WEST SUSSEX COUNTY COUNCIL CONSULTATION

TO:	Arun District Council FAO: Anita Gardner
FROM:	Highways, WSCC
DATE:	09/05/2018
LOCATION:	Land At Asda Superstore, Littlehampton Road, Ferring, BN12 6PN
SUBJECT:	FG/206/17/PL Installation of a Six Pump (12 Filling Position) Petrol Filling station, Drive-to- Pay Kiosk & associated works including Jet Wash, Air/ Water Services & Vacuum Equipment. Additional information received.
DATE OF SITE VISIT:	n/a
RECOMMENDATION:	☒ Advice ☐ Objection ☐ Modification ☐ No Objection ☒ More Information ☐ Refusal
S106 CONTRIBUTION TOTAL:	n/a

Existing PFS Plan

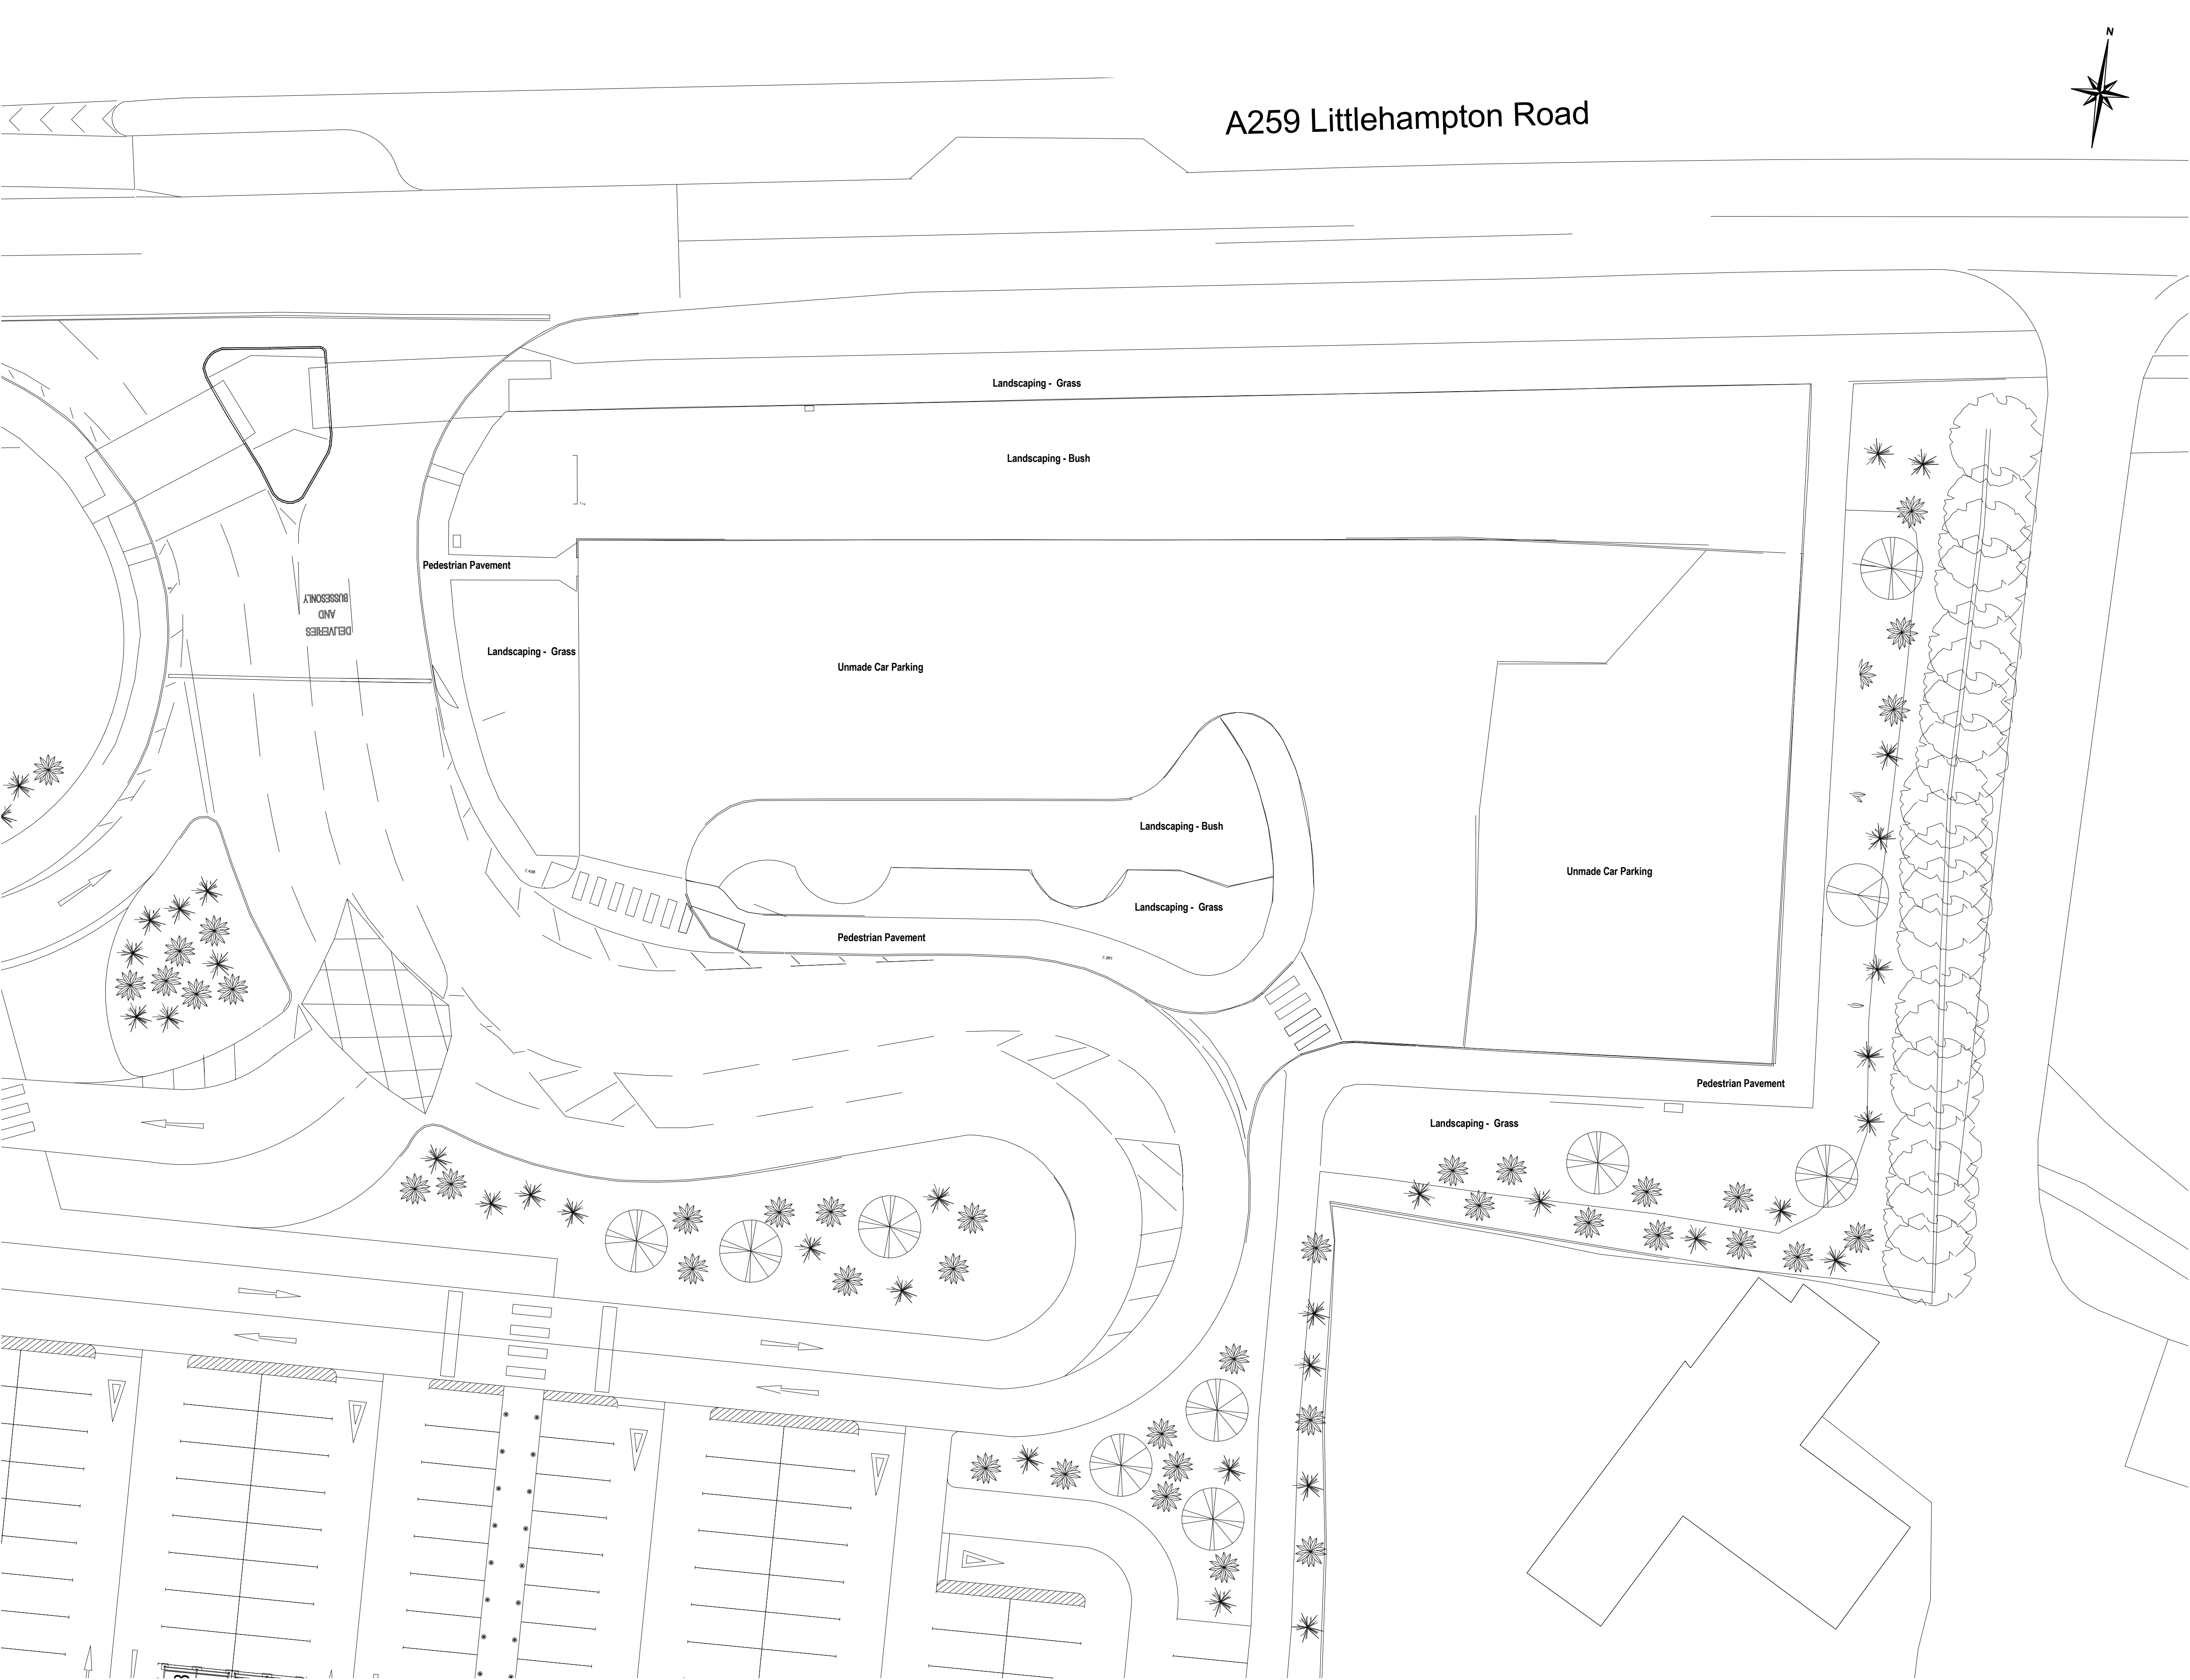
The Technical Note details that the overflow parking area, which the filling station will be built upon, is unmarked and there is no signage directing customers to park there.

It is however evident using Google Streetview data that vehicles do park in this area. It is however unclear if they are associated with the Asda Store.

The existing food store has a gross floor area 11,520 sqm and a defined car parking capacity of 534 car parking spaces, not taking into account the overflow parking area.

WSCC operates a maximum parking standard of 1 spacer per 14 sqm for food retail. This would equate to a maximum parking demand of 823 parking spaces.

The defined parking provision is 289 spaces short of the anticipated maximum demand however the Local Highway Authority does appreciate that parking provisions should be

reduced below the anticipated maximum demand for which accessibility to the site is a key consideration.

On balance, without evidence to the contrary, it would be problematic for the Local Highways Authority to demonstrate that the overflow car parking area is required to serve the operational use of the store as existing. Thus it's subsequent loss creating a highway safety issue, either by way of queuing onto A259 or parking in unsafe locations nearby, would be difficult to substantiate.

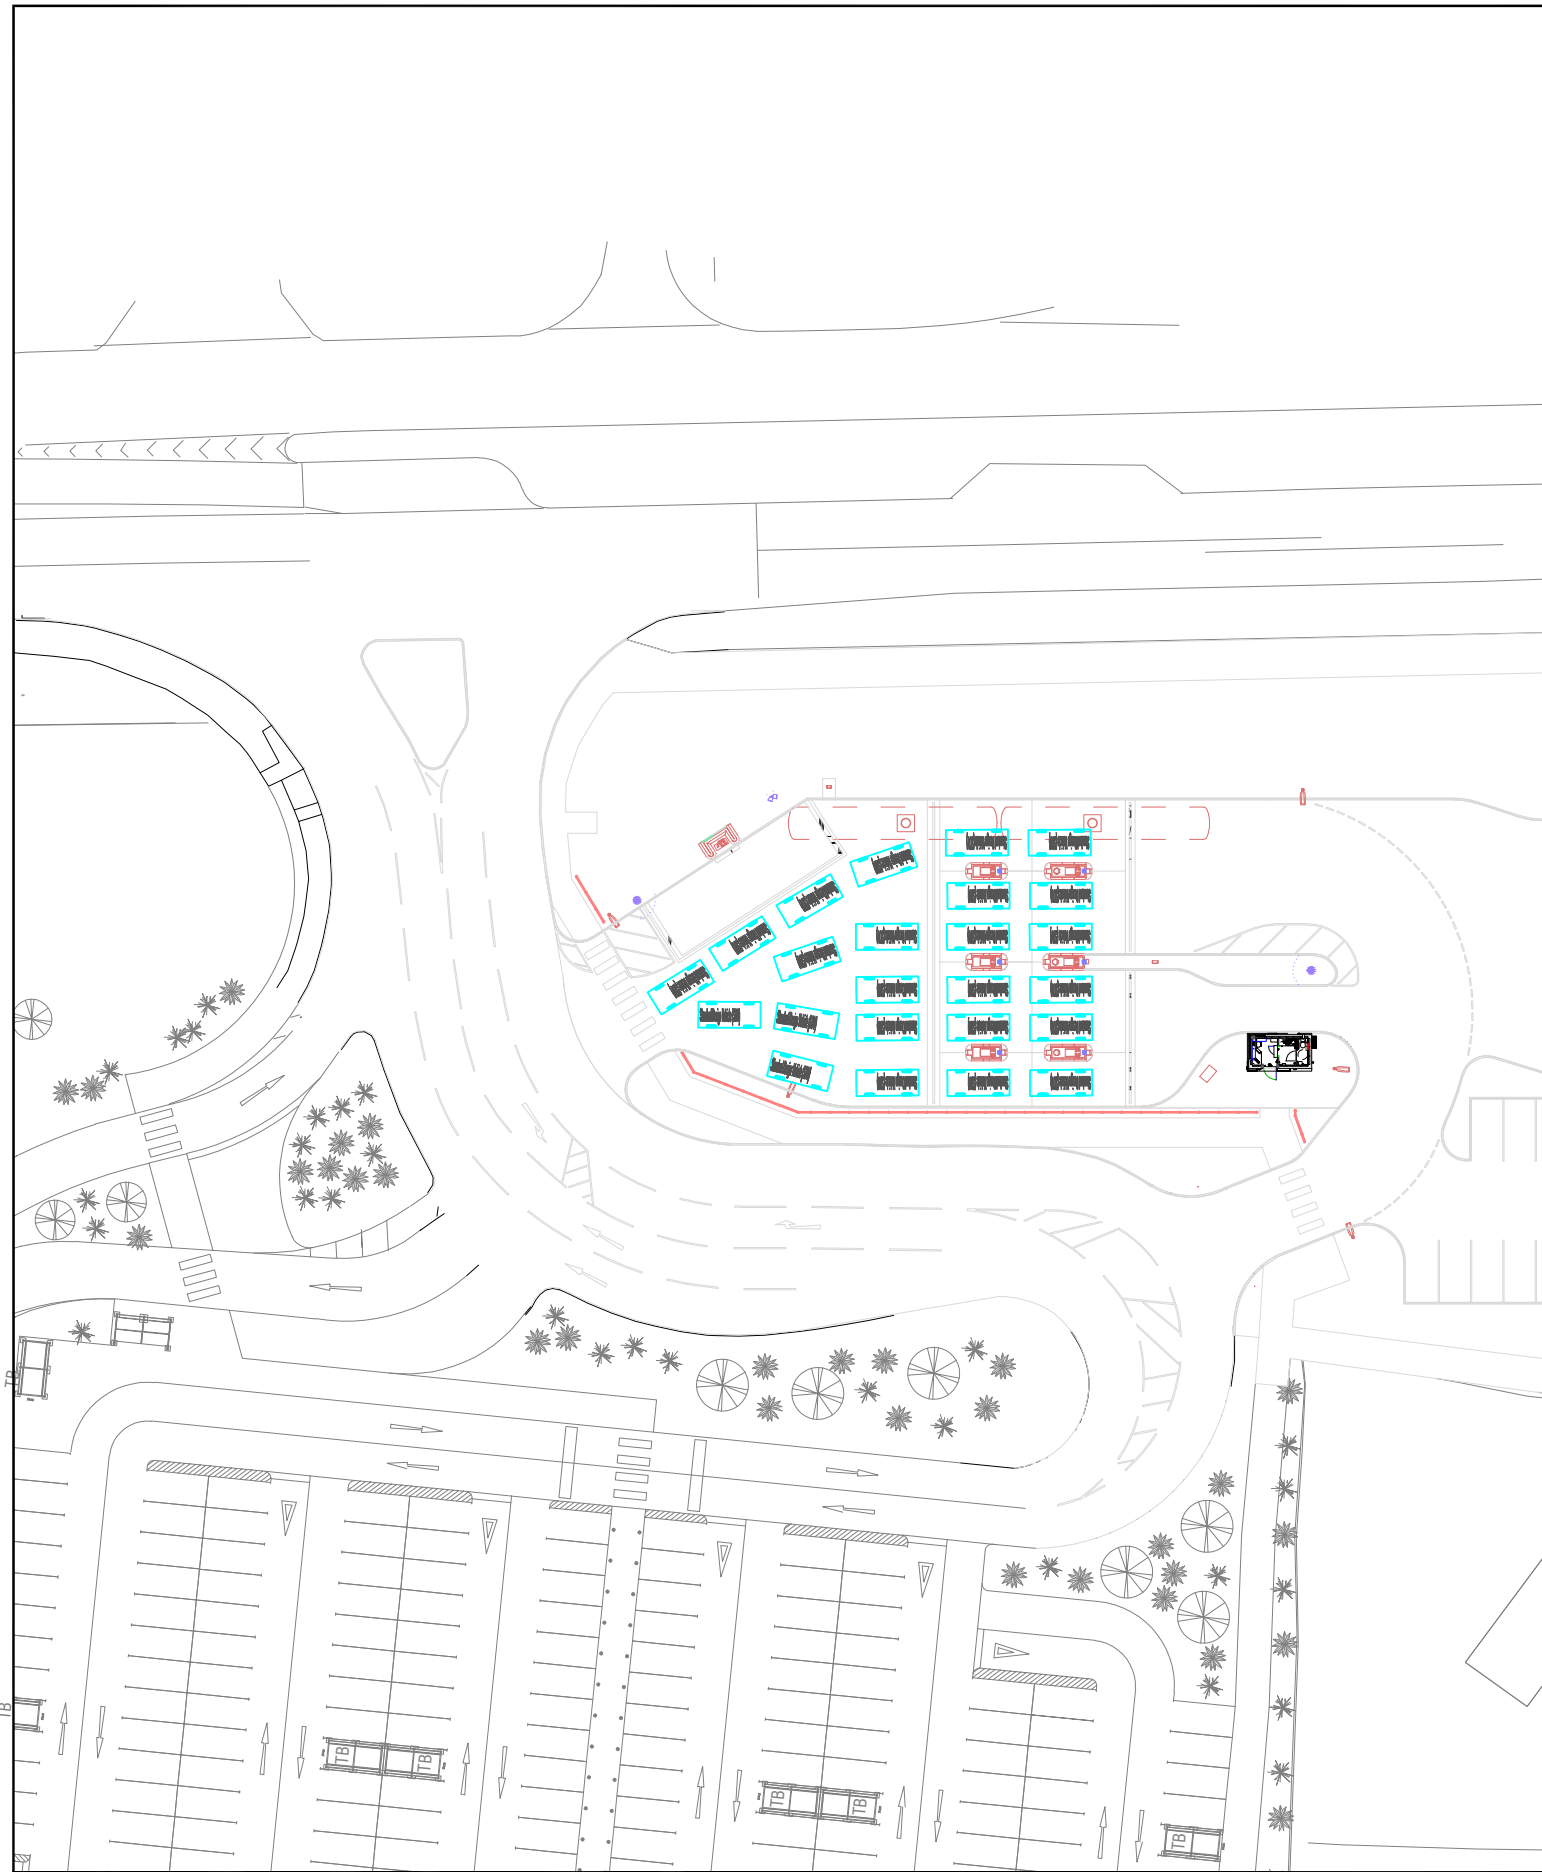
An additional queuing plan has been provided which demonstrated the PFS will have the capacity to contain 24 vehicles within the confines of the site, including cars occupying all filling points.

The Technical Note summaries that this equates to 30% of the overall peak demand create by the PFS as demonstrated in table 4.2 of the weekday, 78 vehicles during the weekday peak (17:00 – 18:00).

This would be considered adequate given the anticipated peak demand. While this would not take into consideration instant demand, such an instant demands would be difficult to quantify and therefore difficult to reasonably mitigate against.
